City of Albuquerque Stormwater Construction Site Inspection Report

ESC File No.	D17E095A	Project Name:	Guthrie's Garage		
NPDES Id. No.	NMR1005KO	Location:	3831 Masthead Street		
7/12/2023	Owner		Contractor NMR1005M8		
Operator	Headstart Enterprises LP		Wilger Enterprises		
Contact name & title	Jim Guthrie		John Wilger		
e-mail	jim@carcrafters.com		jwilger@wilger.com		
Contact Phone #	881-8889		505-345-2854		
COA Inspector	Doug Hughes		Start/End Time:	11:45AM	
Construction Phase:	Cleared				
Type of Inspection:	Regular	Storm Event	Post Storm Event >0.25"	311/Complaint	Follow Up
Weather at time of inspection?	Cloudy		Temperature: ~	98	
Estimated date of last storm 0.25" or greater	3/17/2023

ENGINEER'S SEAL RONALD R. BOHANNAN NEW MEXICO PROFESSIONAL ENGINEER 7868 4-17-23 RONALD R. BOHANNAN P.E. #7868	3831 MASTHEAD ST ALBUQUERQUE, NM	DRAWN BY pm
EROSION CONTROL PLAN		DATE 4-17-23
		DRAWING
		SHEET # SW-1
		JOB # 2022002

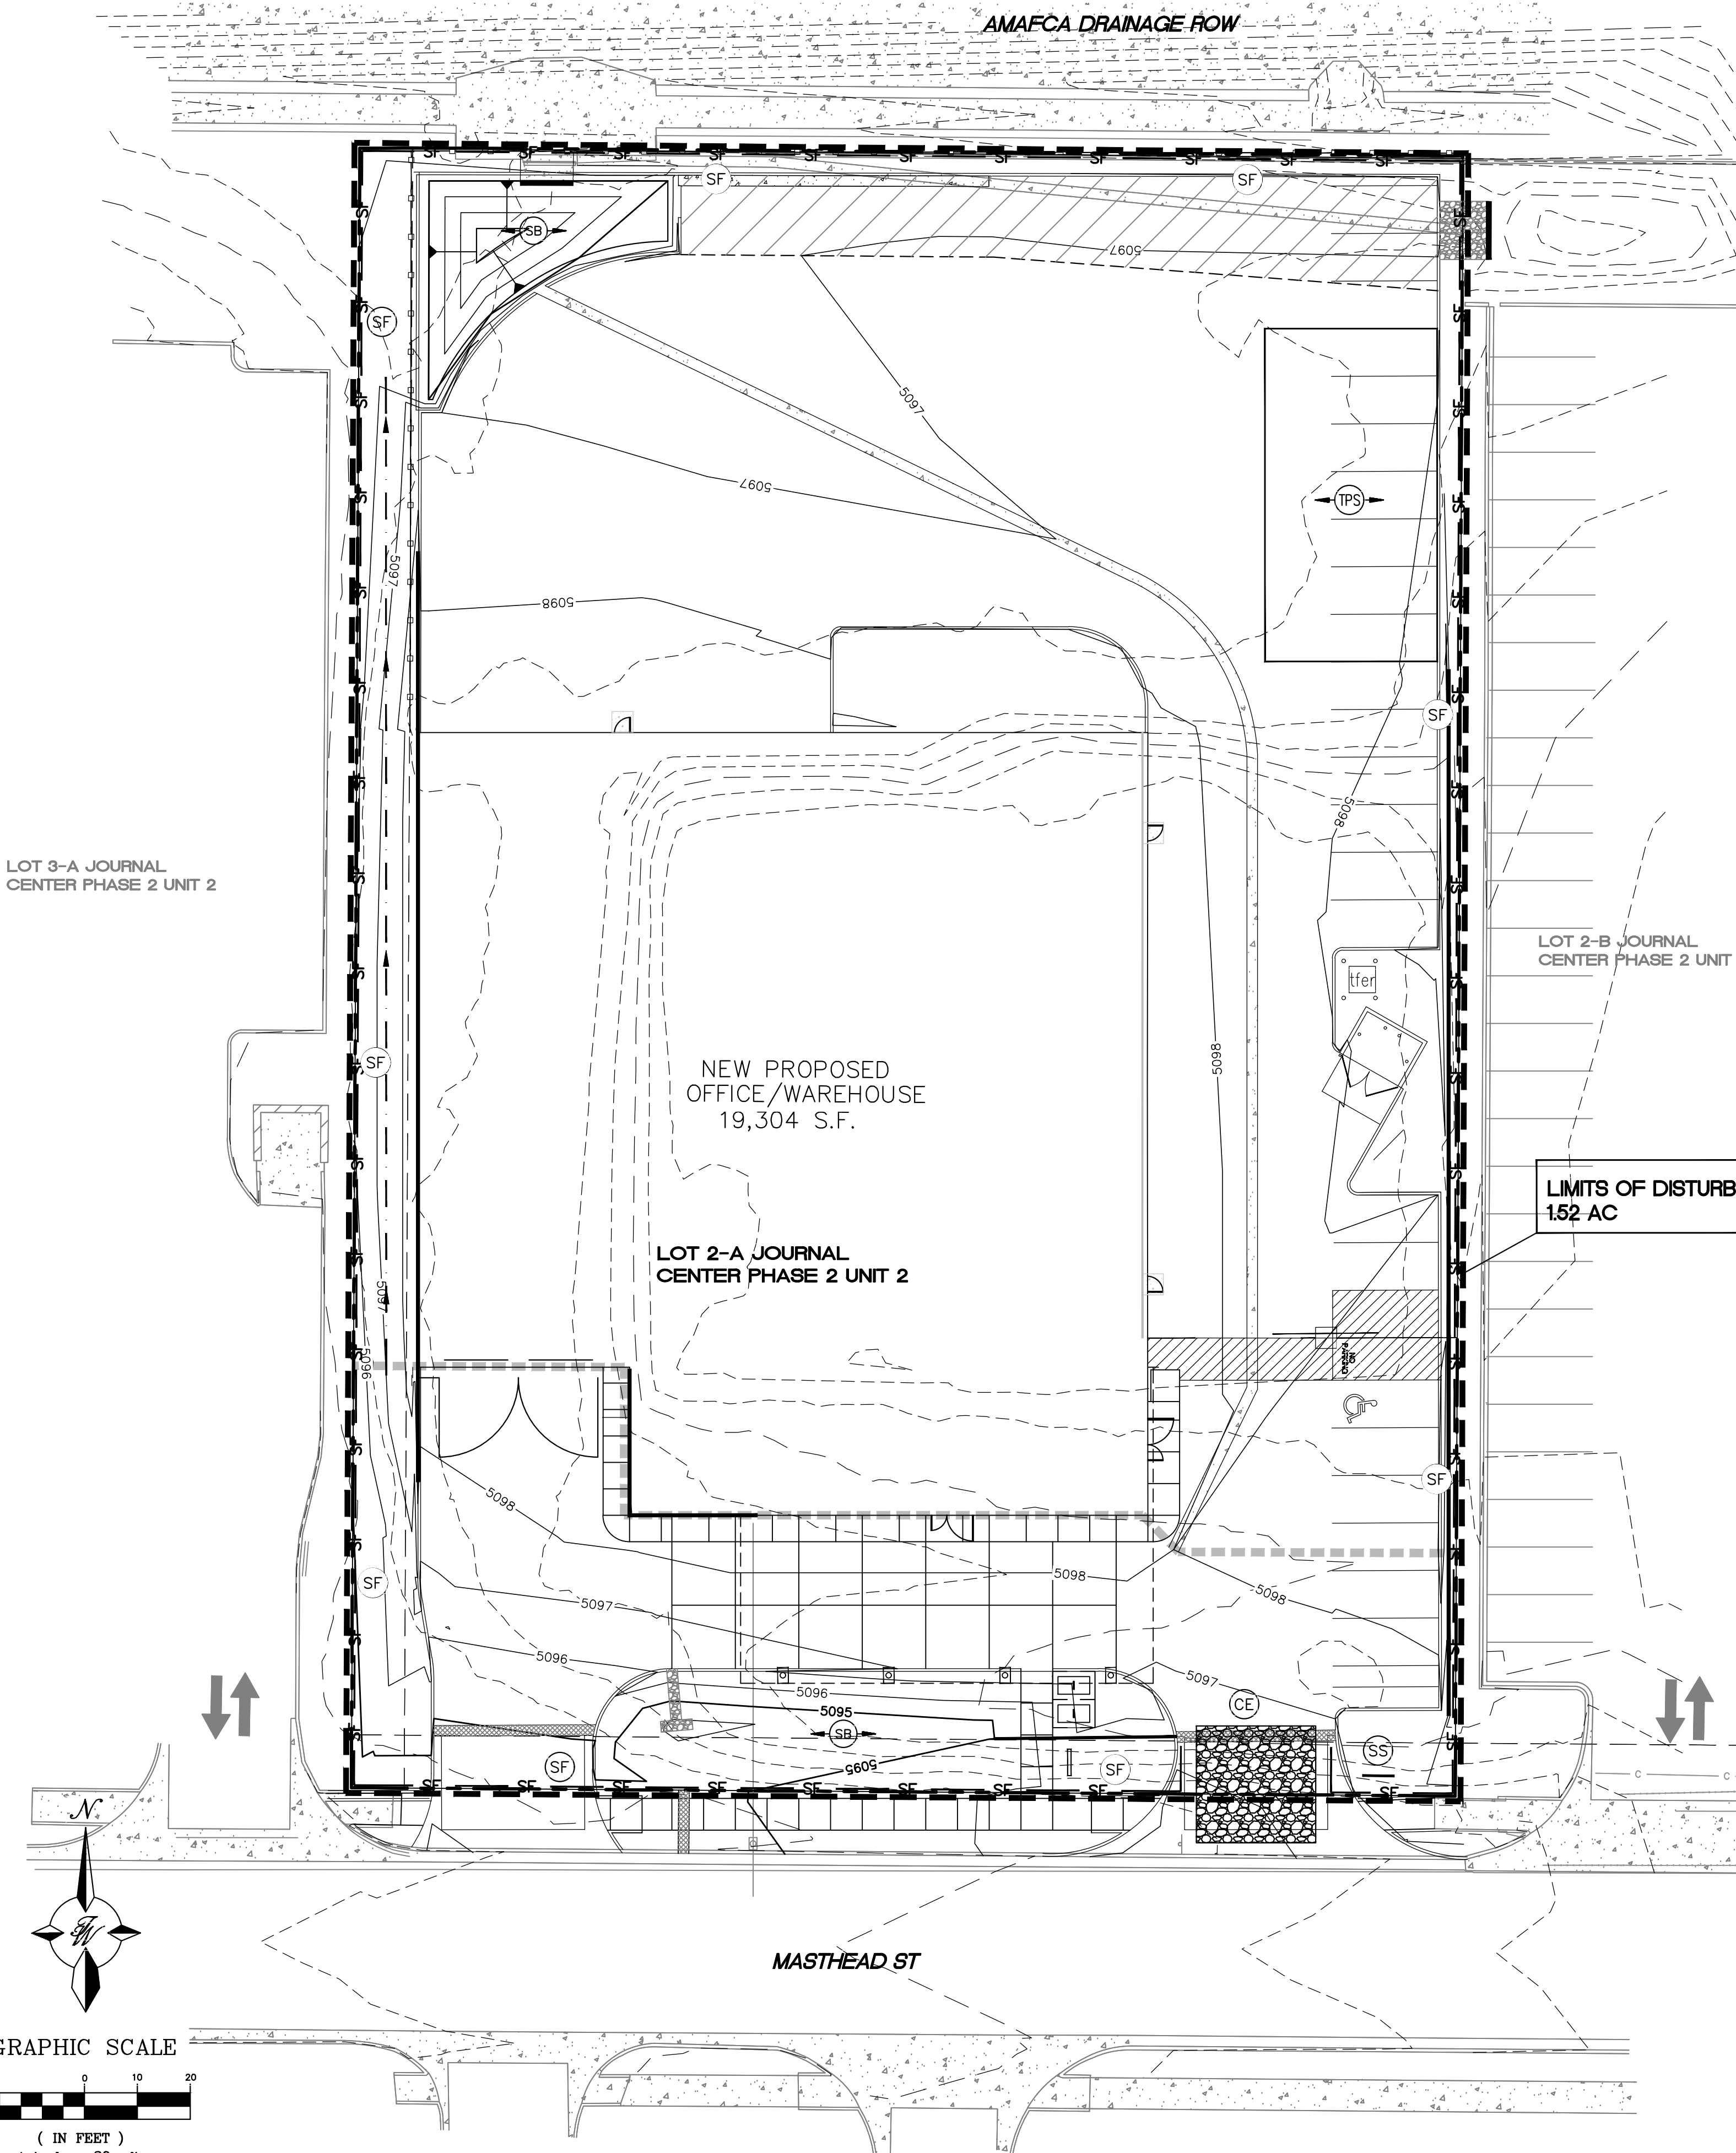
Item Number	Deficiency/ Corrective Action
1	Your SWPPP wasn't up-to-date and Self inspection reports were not available on-site during the inspection in violation of City Ordinance § 14-5-2-11(C)(1) and in violation of CGP 7.3. The Stormwater team members were not identified, in violation of CGP Part 6 and Part 7.2.2. The operators Certification Statements were not signed in violation of CGP 7.2.10. Training Certificates may be incomplete per CGP part 6 and 7.2.8. Required Mitigation: The SWPPP and inspection reports must be kept up-to-date per CGP 7.1 and available on-site per CGP 7.3. and City Ordinance § 14-5-2-11(C)(1). Corrective action reports are required to reset controls that were incorrectly installed and must be reset (below) per CGP Part 5.
2	BMPs were installed incorrectly and were not properly maintained. The Construction Entrance (CE) is installed in the wrong place. The CE is in the low corner of the lot creating hole in the Silt Fence and allowing stormwater runoff to escape the site without ponding at the planned silt fence per approved SWPPP Map. The Silt fence is also down and full of sediment in several locations on the west side of the site. The swale on the west side drains to the street, it must drain to the pond on the north. Mitigation: Install controls and establish drainage patterns in accordance with the approved plan making them operational, or completing the repair, by no later than seven (7) calendar days from the time of discovery per CGP 5.2.1. 3. Ensure that all stormwater controls (BMPs) are maintained and remain in effective operating condition during permit coverage per CGP 2.1.4. If at any time you find that a stormwater control needs routine Maintenance, you must immediately initiate the needed maintenance work and complete such work by the close of the next business day.
